Action Point	Response
6	Confirmation that Northumberland County Council (NCC) are satisfied with text in Art 7(b)(ix).	From a highways perspective, we are satisfied with the text as set out in Art 7(b)(ix)
7	NCC to respond to the Applicant's response to ExQ1 DCO.1.39 and DCO.1.40, in relation to Art 11.	The applicant's response to ExQ1 DCO.1.39 confirms that the revised DCO has consistency in notifying the Street Authority at 6 weeks and, as such, have no comments to make. (Noting DCO.1.40 is linked more to Article 12 so comments have been made on this under Point 8)
8	Applicant and NCC to consider Art 12 and identify any matters of disagreement.	Following on from our meeting with the applicant on 15th February, the applicant's consultant has shared notes of the meeting on 10th March, which have provided clarity in relation to Article 12, along with the points of clarity made in the Hearing Sessions. It is understood that these notes will form subsequent iterations of the Statements of Common Ground to which we will comment and confirm.

Response to Point 36

**Figure 4-6 - West Linkhall Road Proposal to use A1 Drainage Network**

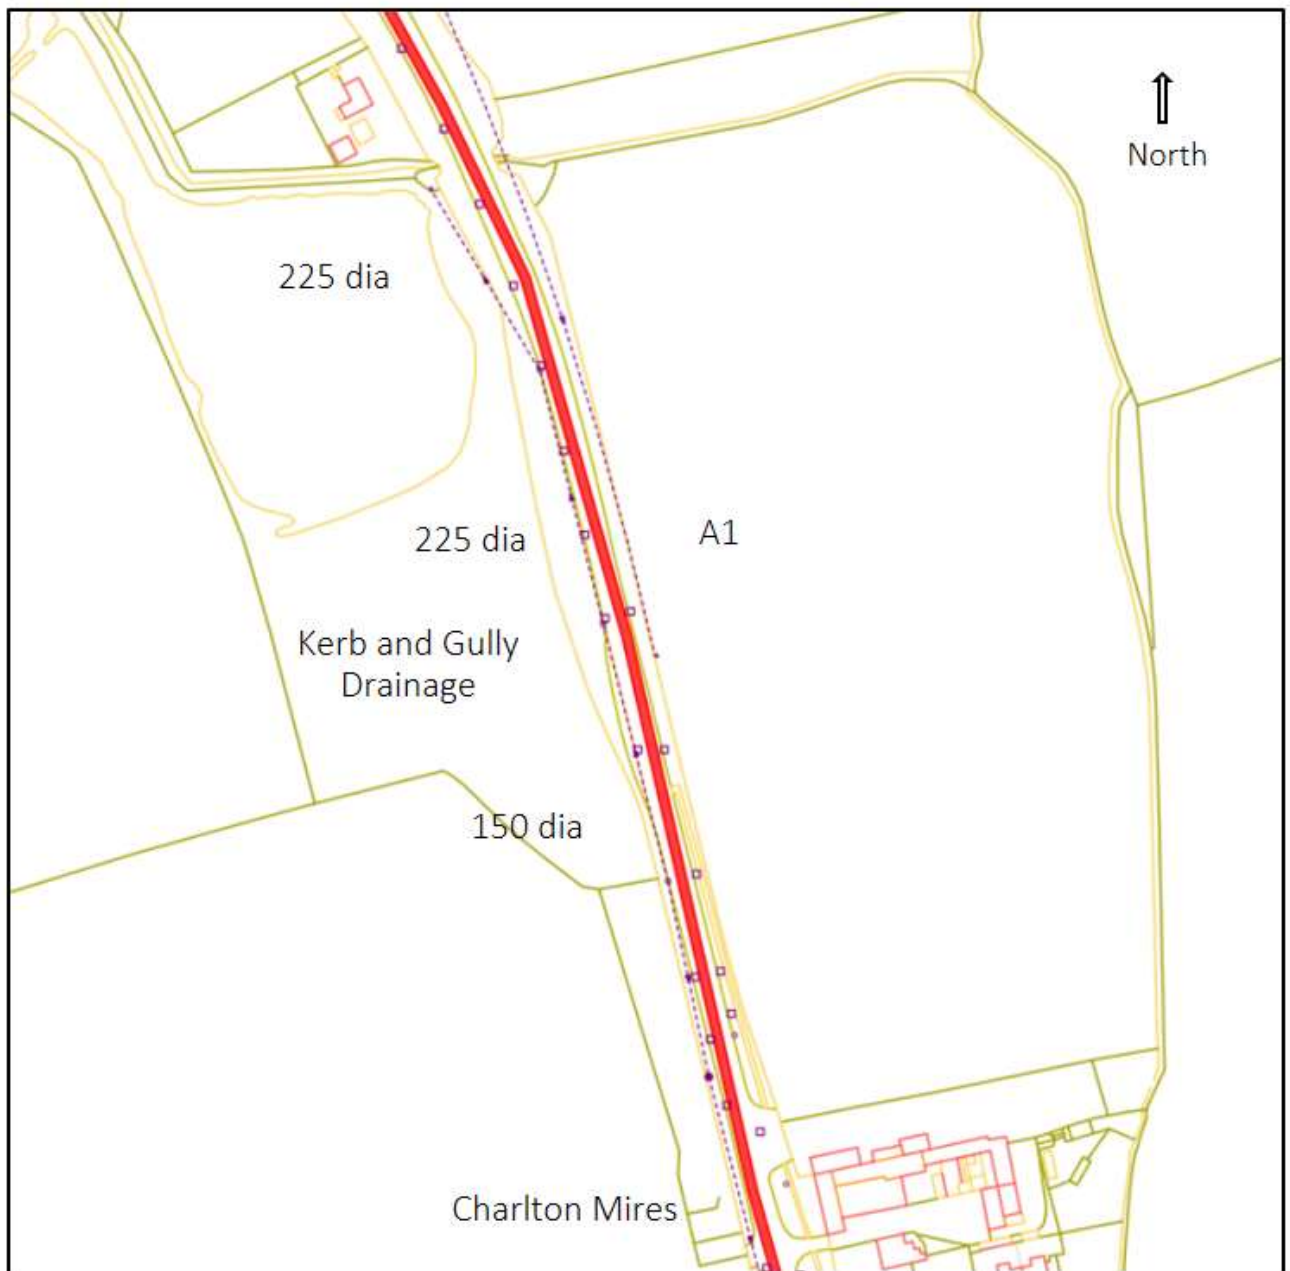
<p>nature of the Stopping Up and the resultant status/ownership of the stopped up highway, as per NCC's comments on the Applicant's response to DCO.1.44.</p>	<p>status and ownership of the Stopped Up highway. The Proposed Highway Adoption & Maintenance Responsibilities Plans (ref REP3-003) was used to facilitate this meeting although it should be noted that these plans only consider the future carriageway elements of the scheme and not the full extents of the highway associated with these sections of carriageway. Whilst the Maintenance Boundary Technical Note (ref REP1-049) indicates this additional information for the new grade separated junctions and the new local roads within Part B of the proposals, we would seek this level of detail for all elements of the scheme to ensure clarity over future maintenance liabilities for the network that would form the Local Highway Network. This exercise will also allow for clearer definitions of Stopped Up highway to be defined within the Rights of Way and Access Plans.</p> <p>During this meeting it was identified that the extent of the new Local Highway Network forming the East Linkhall Road (Works Package 29i) may require amendment in relation to the future designation of Local Highway Network and the location of the subsequent Private Access rights at location PA16/4 on the Public Rights of Way and Access Plans. A design solution similar to that proposed at the southern end of the de-trunked section of the A1 to the north of Priests Bridge (around location PA3/3 on the Public Rights of Way and Access Plans) may be required although we await revised proposals in this respect from the applicant as part of their review of the East Linkhall Road and the revised General Arrangement plans showing the two-lane carriageway as discussed in the Hearing Sessions.</p> <p>Further in the meeting comments in relation to drainage on the East Linkhall, West Linkhall and Rock South Farm Access Roads was discussed. From further examination of the documents and in particular the drainage strategy for Part B (APP-314 - 6.8 Environmental Statement - Appendix 10.4 Drainage Strategy Report Part B.) by the Council as Local Highway Authority, it has become evident that the current proposals for these roads do not include positive drainage of the road to an outfall (although it is noted and accepted that the West Linkhall drainage proposals</p>

<p>do partially utilise the existing A1 drainage). The lack of drainage provision for these roads would mean that they were not acceptable to the County Council for adoption. This is to be looked into by the applicant as an action from this meeting and discussions are on-going with the Applicant and their consultants to resolve this matter. The adoption of SuDs basins also forms part of these ongoing discussions</p> <p>Therefore, whilst the principles of the Stopping Up and resulting status are better understood we cannot confirm that no further clarification is required until the actions from the meeting on 2nd March have been tabled and reviewed.</p>
17	Written update with progress between Applicant and NCC in relation to Article 16	As stated in the response to Point 12, a meeting was held in relation to Stopping Up elements and resultant status/ownership of the Stopped Up highway and the future highway on 2nd March. This process is ongoing and we await the further clarifications and revised plans as stated in the response to Point 12. This work will feed into any amendments to Article 16 and associated Schedules.
